OFFICIAL NOTICE OF DECISION

CITY OF ALBUQUERQUE
PLANNING DEPARTMENT
DEVELOPMENT REVIEW BOARD

Project# 1006868

16DRB-70009 VACATION OF PUBLIC WATER AND SEWER EASEMENT

DATE:	11.13.2007	sheet-
SCALE:	1"=40'-0"	LS1
		of

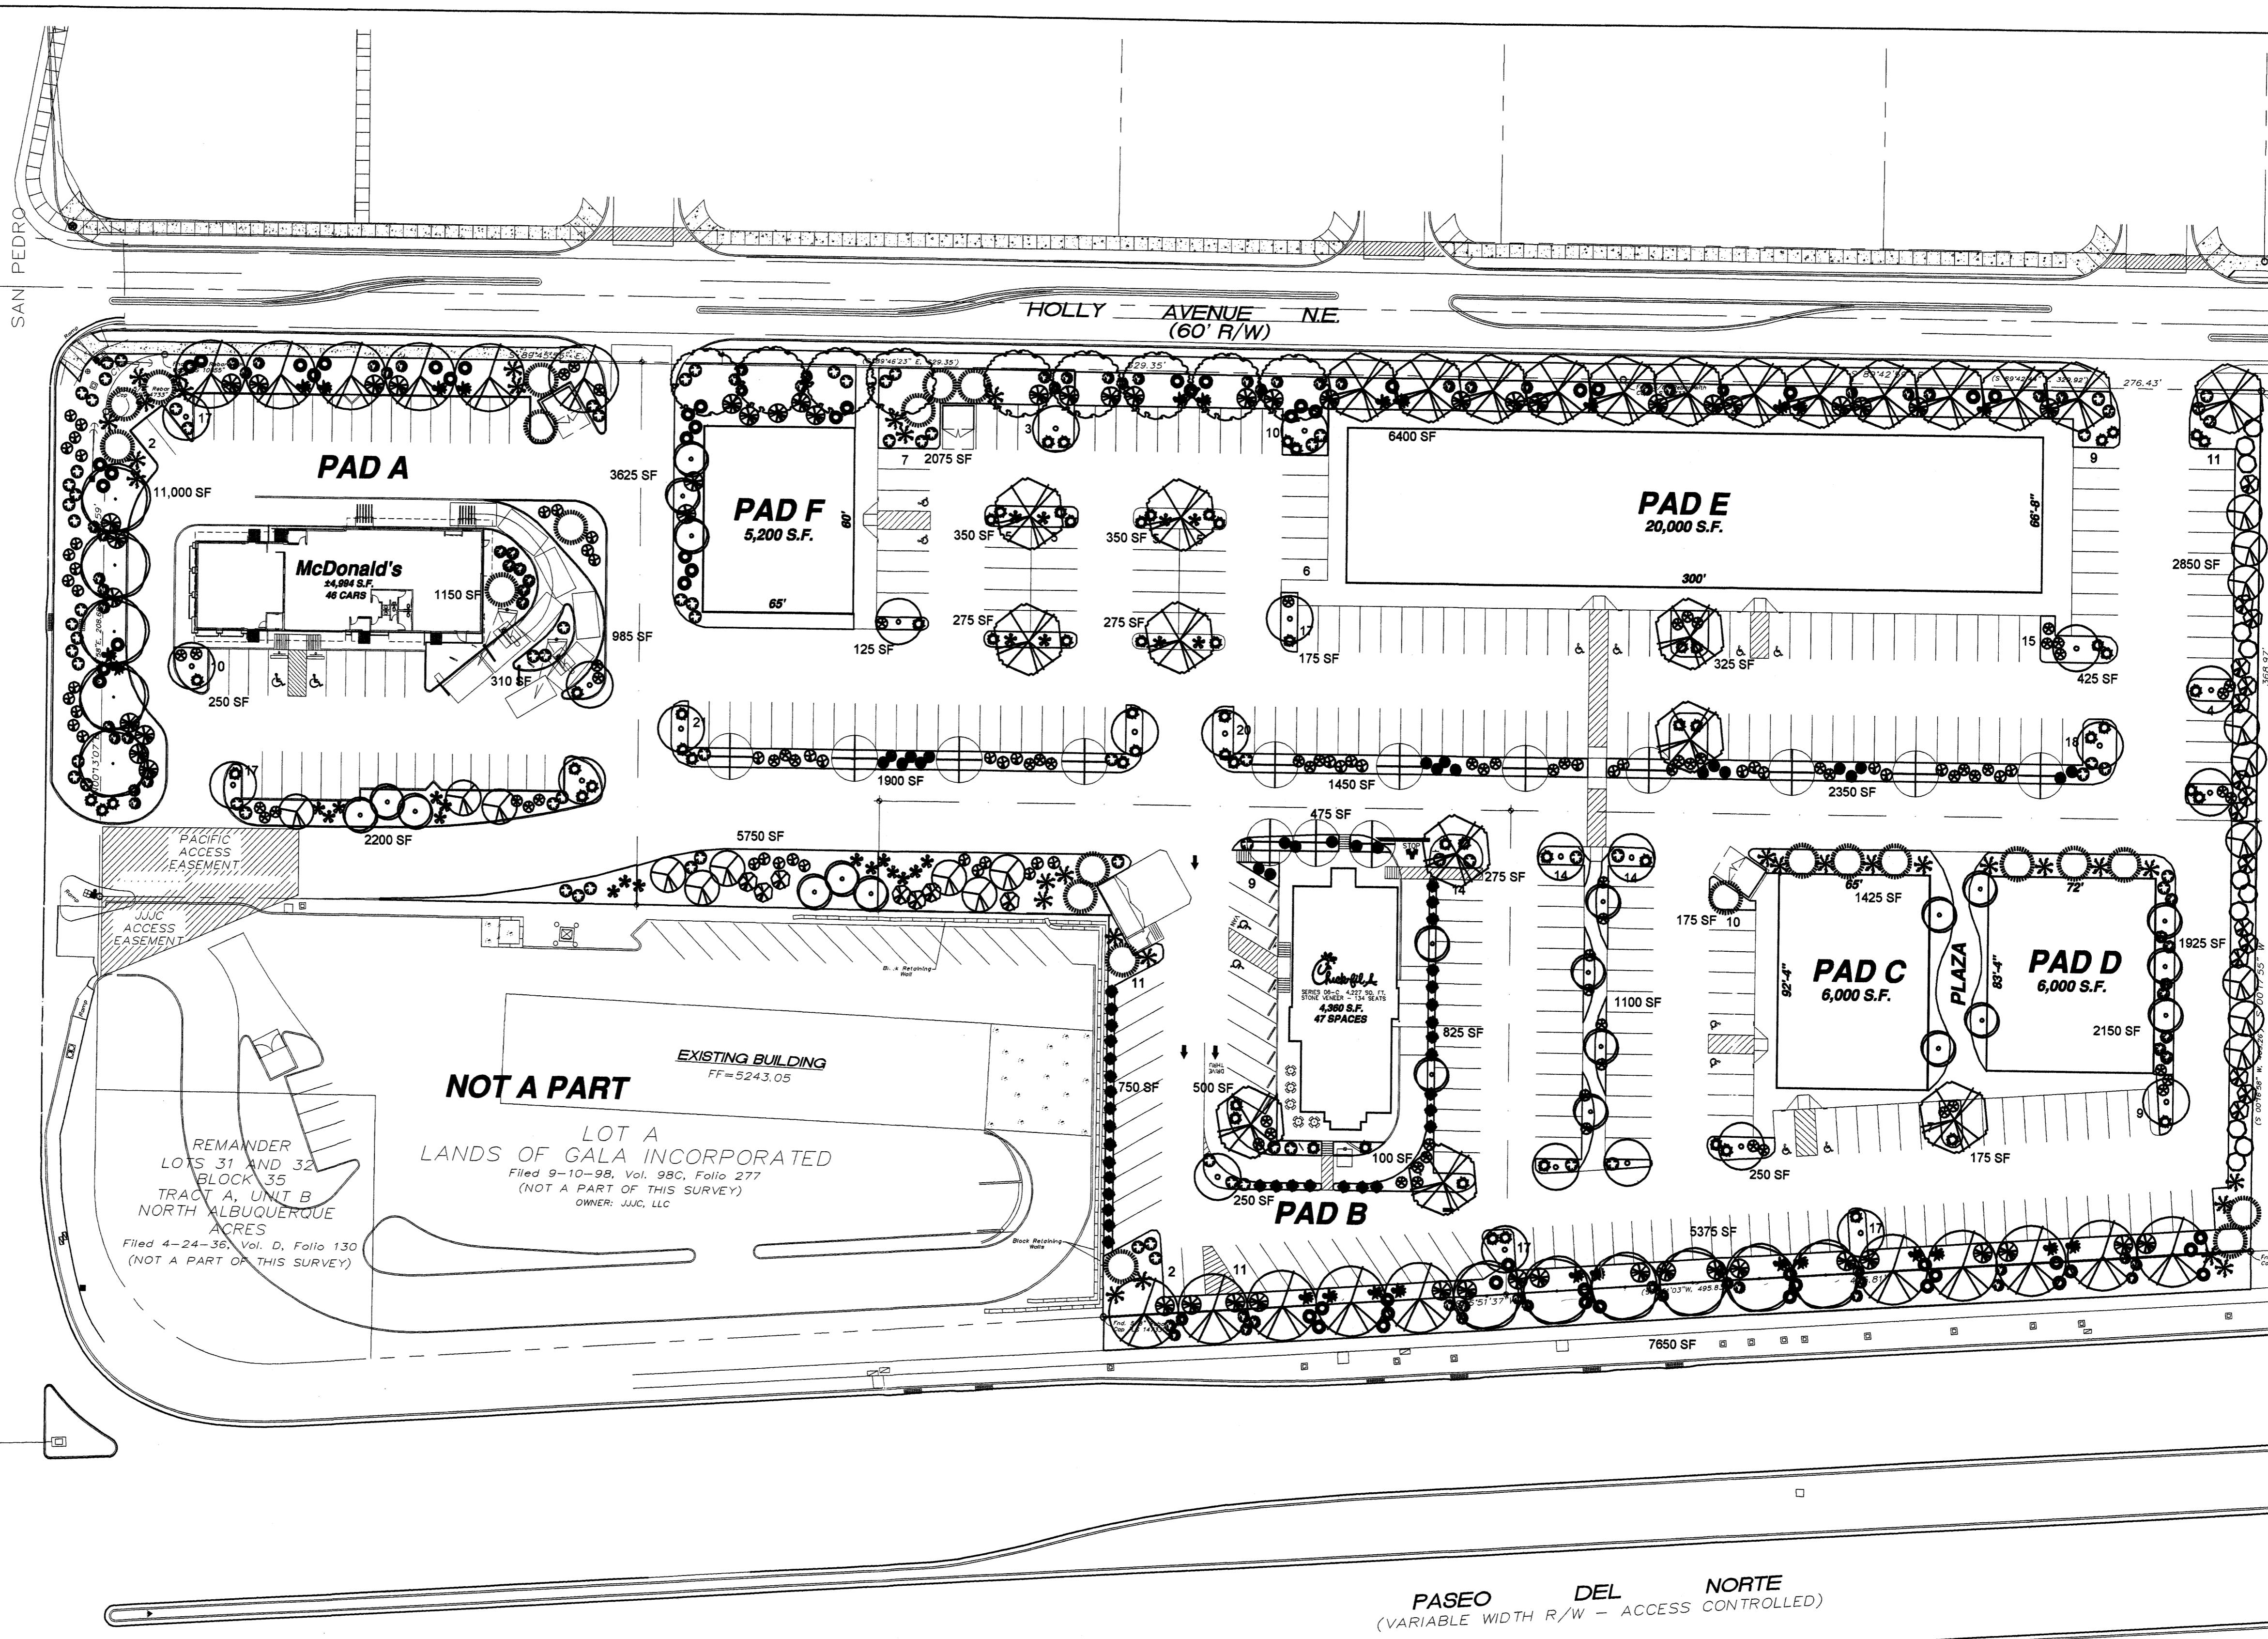
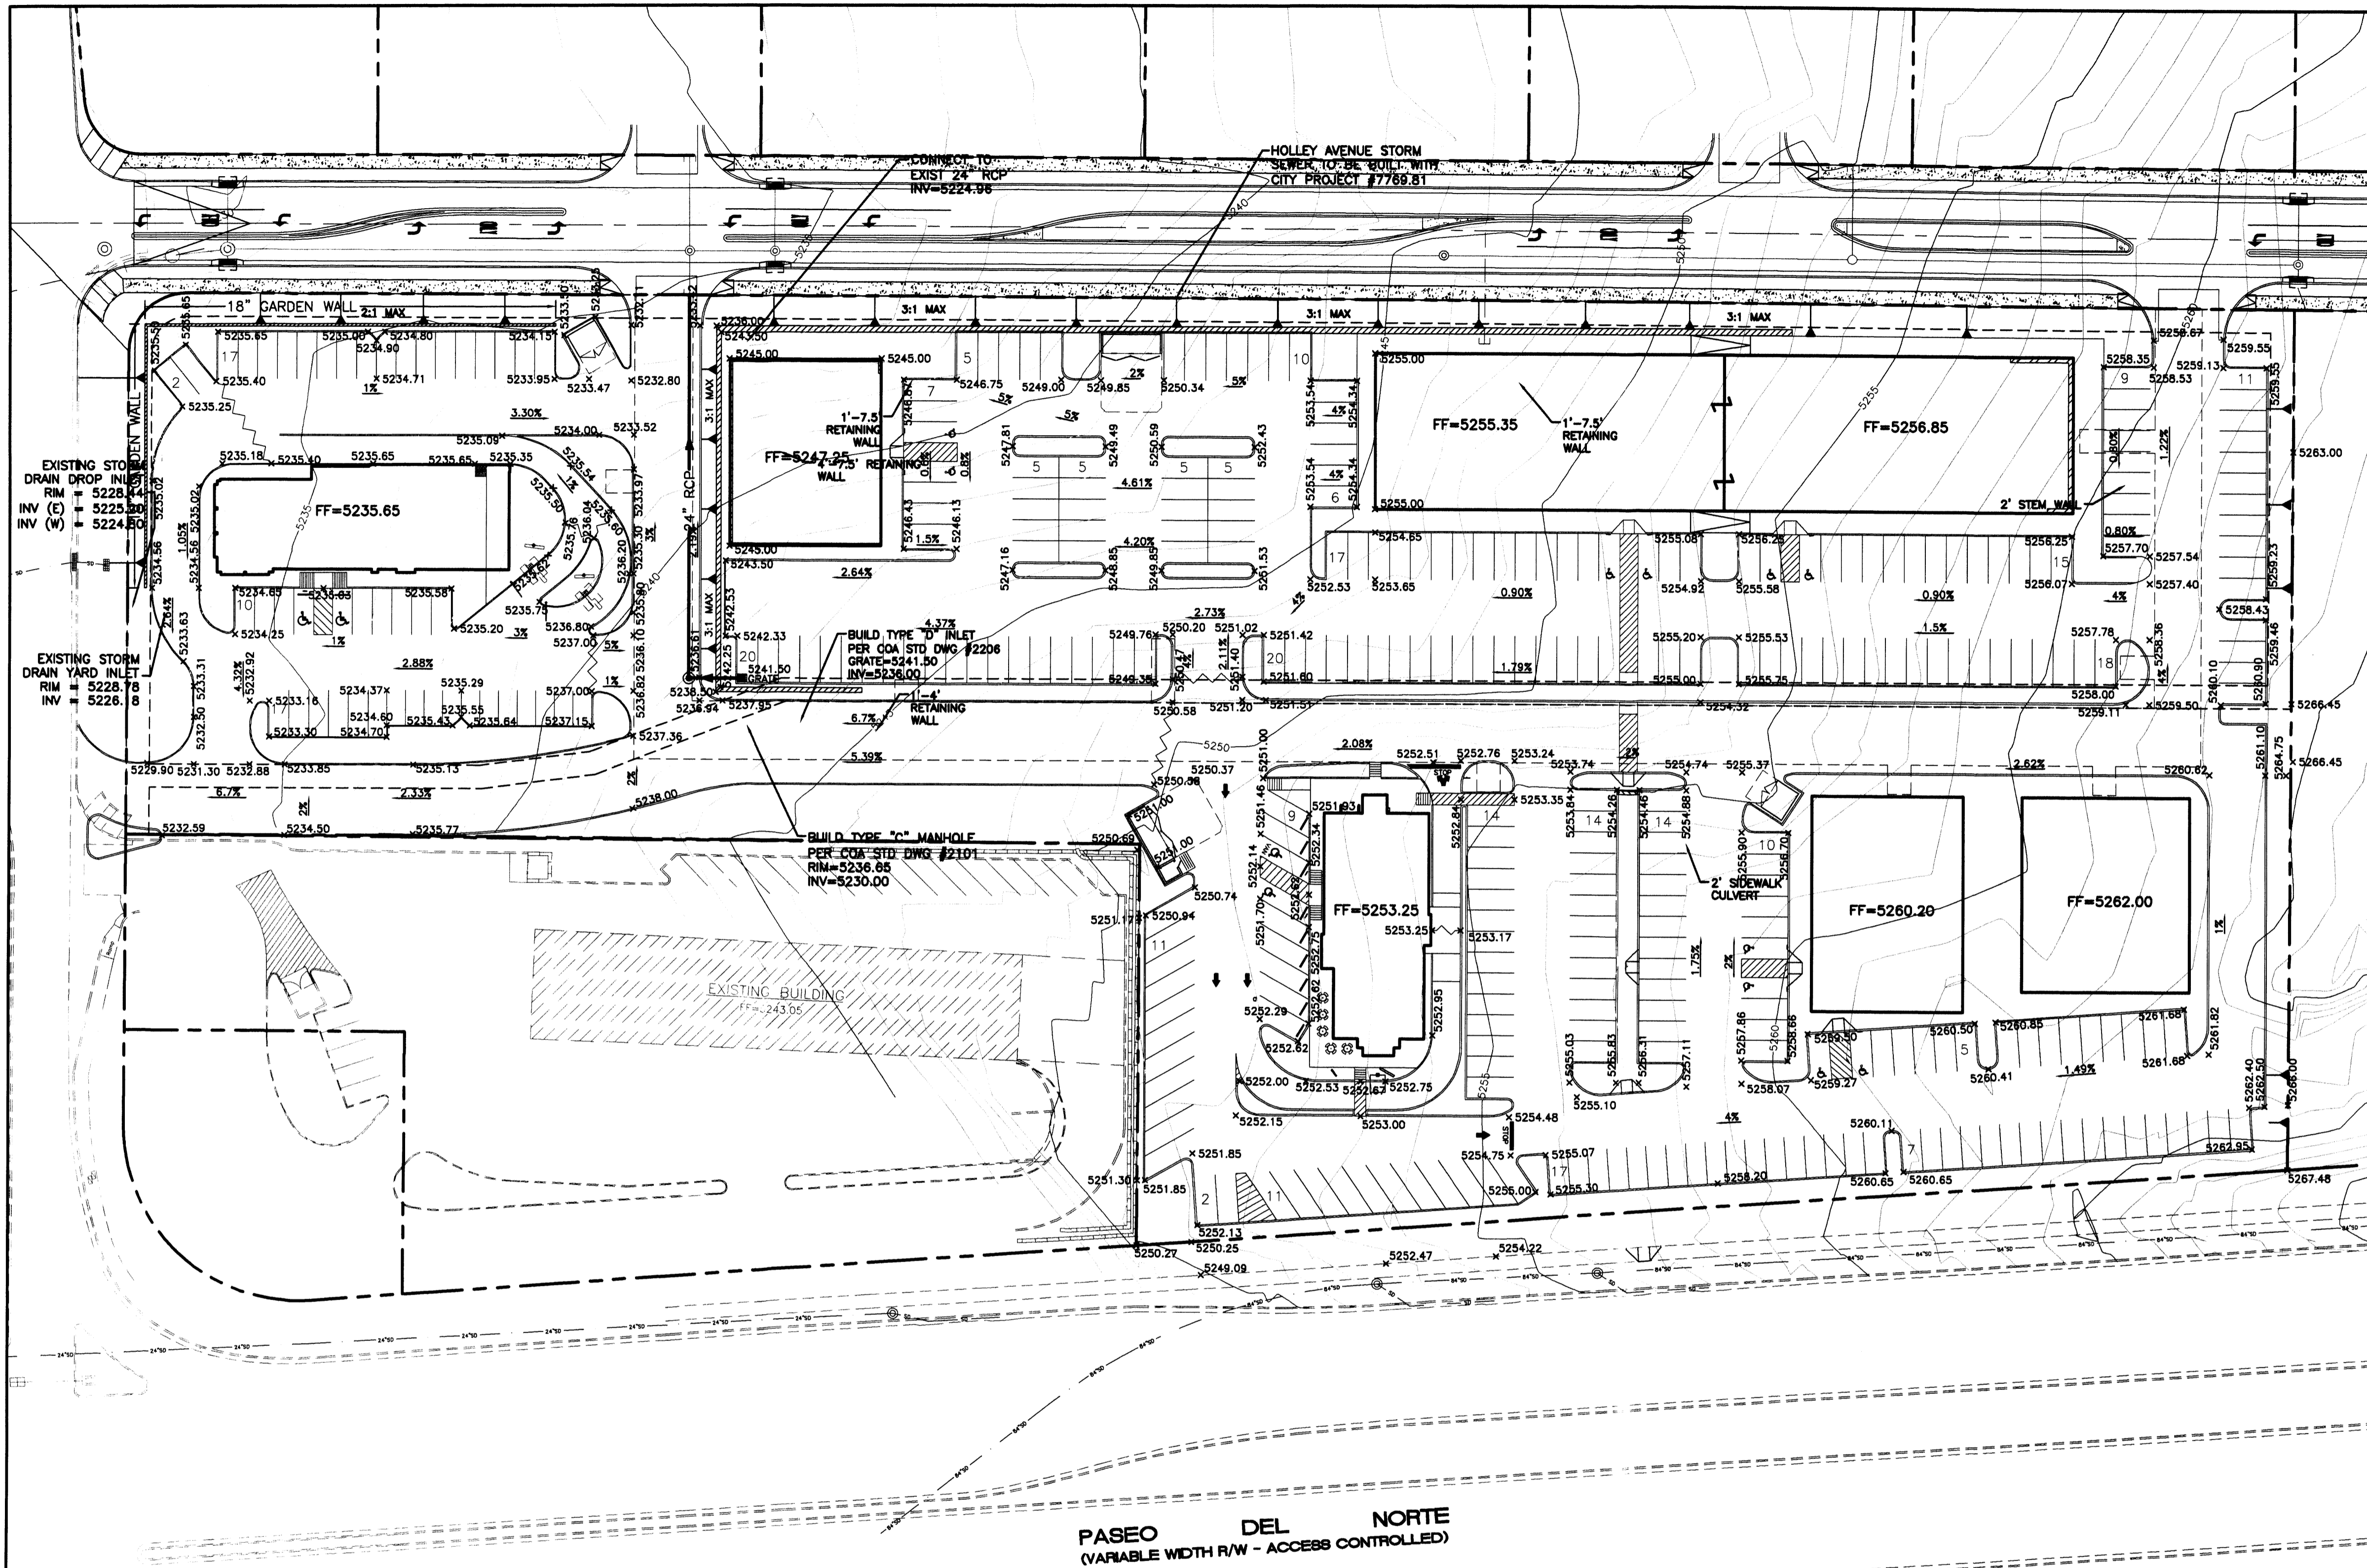
Site Plan for Subdivision Landscaping needs to be included/
constructed with the expansion of Lot 3.
